Date: 18 October 2018
Our ref: 259977
Your ref: P/140/16/OUT

Planning consultation: Habitats Regulations Assessment (HRA) of the Outline application for access only - mixed use development comprising of up to 400 dwellings, a care home with up to 70 beds, a Local Centre comprising up to 2000sqm of A1/A2/A3/D1/sui generis floorspace, provision of land for a 1FE primary school (with sufficient space to ensure that it is expandable to 2FE), provision of land for a scout hut, safeguarding of land to help link the site to the Pagham Harbour Cycle Route & other community uses including public open space & allotments with some matters reserved.

Location: Land South of Summer Lane & West of Pagham Road Pagham

SUMMARY OF NATURAL ENGLAND'S ADVICE

Fig 1 – Eco 1

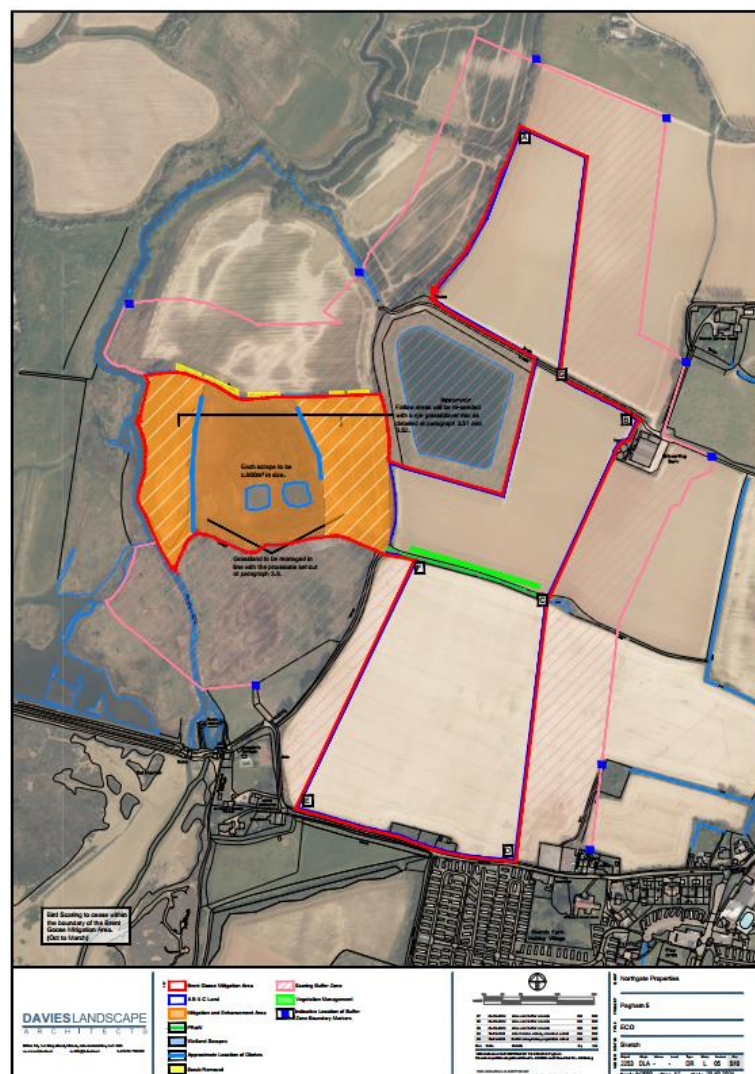
- Measures to minimise disturbance to brent geese foraging within fields adjacent to the application site.
- A detailed habitat management plan for the brent goose mitigation area should be produced, which sets out the habitat management over the whole 18.5ha area. This plan must ensure no net loss of foraging habitat available to brent geese. The plan should be costed and set out who will carry out the management work.

However, as mitigation measures must now be considered through an Appropriate Assessment, Natural England's advice is that your Authority must be certain that they will be deliverable and effective. Our view is, therefore, that the Habitat Management Plan should set out the grassland/crop to be planted over the whole of the 18.5ha area, with the objective of maintaining the same amount of foraging resource as will be lost to the application site. As more geese can forage on a given area of permanent pasture (as it supports a greater biomass and is available throughout the season) the arable lost can be replaced with a smaller amount of grassland. However, a greater area of either grassland or winter cereal/clover, than currently proposed (ie greater than 5ha) will be required to maintain the foraging resource².

The Habitat Management Plan should be costed and set out who will be carrying out the habitat management work. Provided that the Habitat Management Plan is required to ensure no net loss of
